WELWYN HATFIELD COUNCIL – DEVELOPMENT CONTROL
DELEGATED REPORT

APPLICATION No:	S6/2007/17019/AD
------------------------	-------------------------

The application seeks advertisement consent for the erection of 5 different signs which are as follows:

6m high Totem Sign (Externally illuminated)

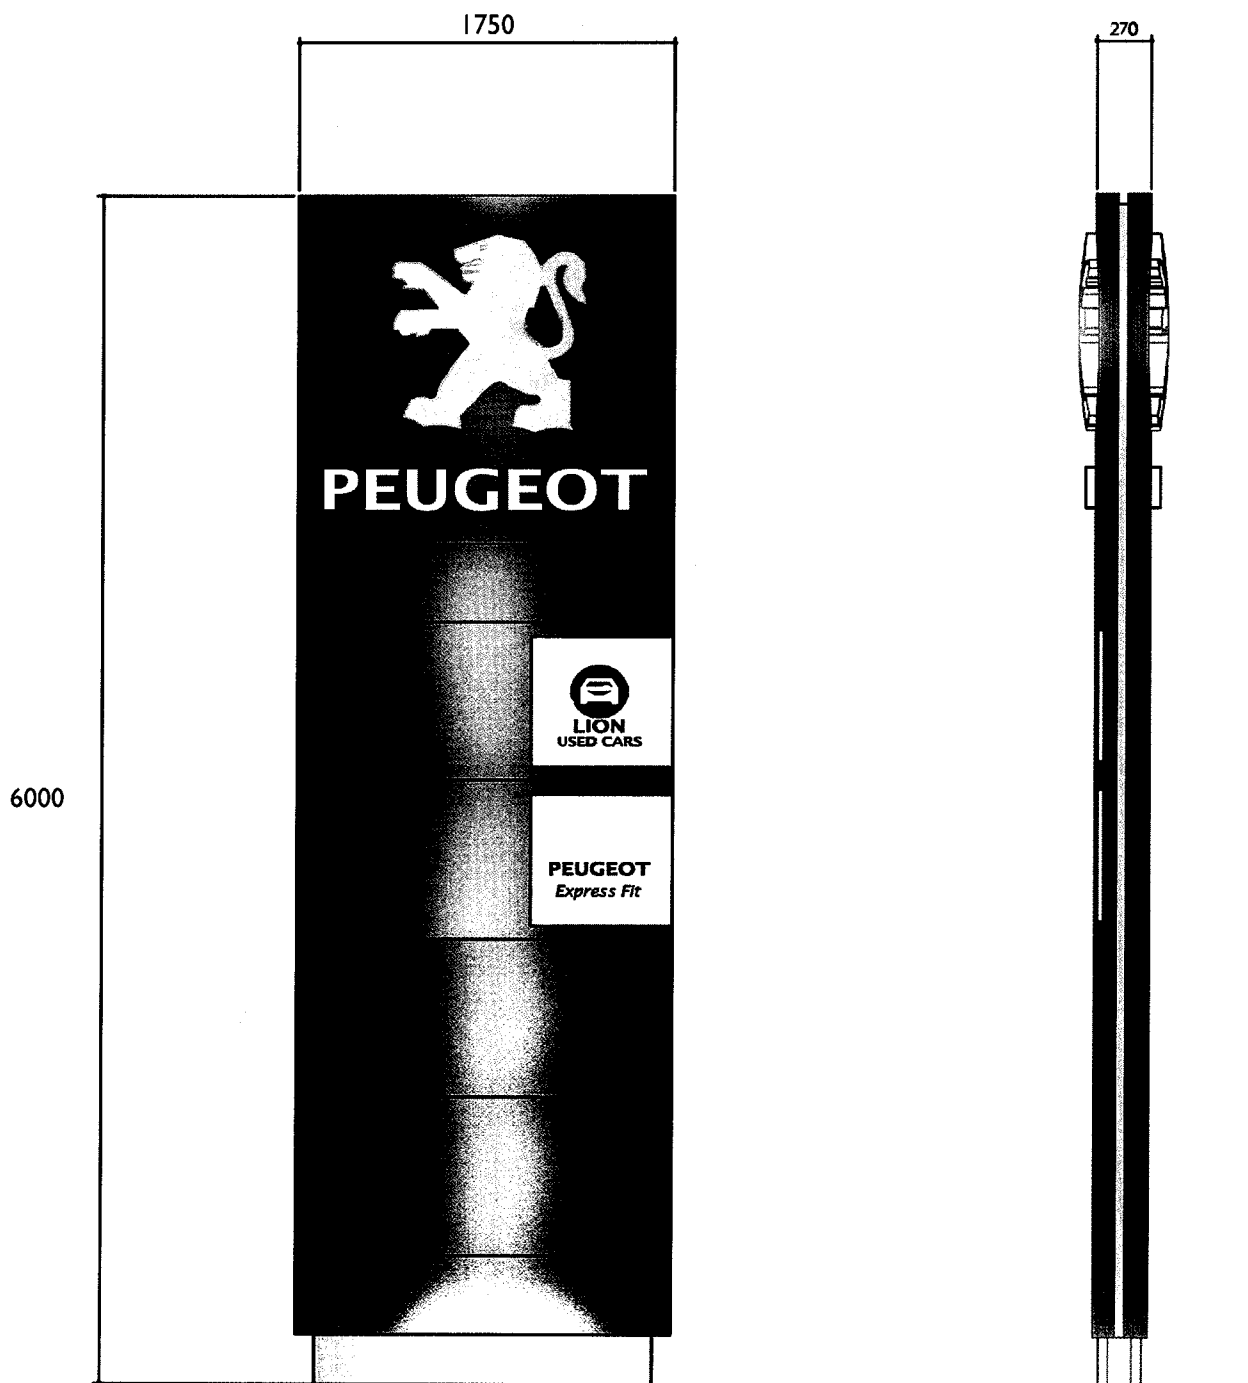
The freestanding sign to the front of the site would be the most prominent one of those proposed, however, through negotiation the original one (which was 6.0 m high and 1.1750 m wide) has been reduced to 4m in height with a width of 1.17m. This reduction is much more in keeping and scale with the character of the streetscene, particularly as the blue colour of the base is visually prominent. It would also be reasonable to say these 'types' of sign are now a more common feature often found in the forecourt of petrol stations and streetscenes, although, this site is a car dealership.
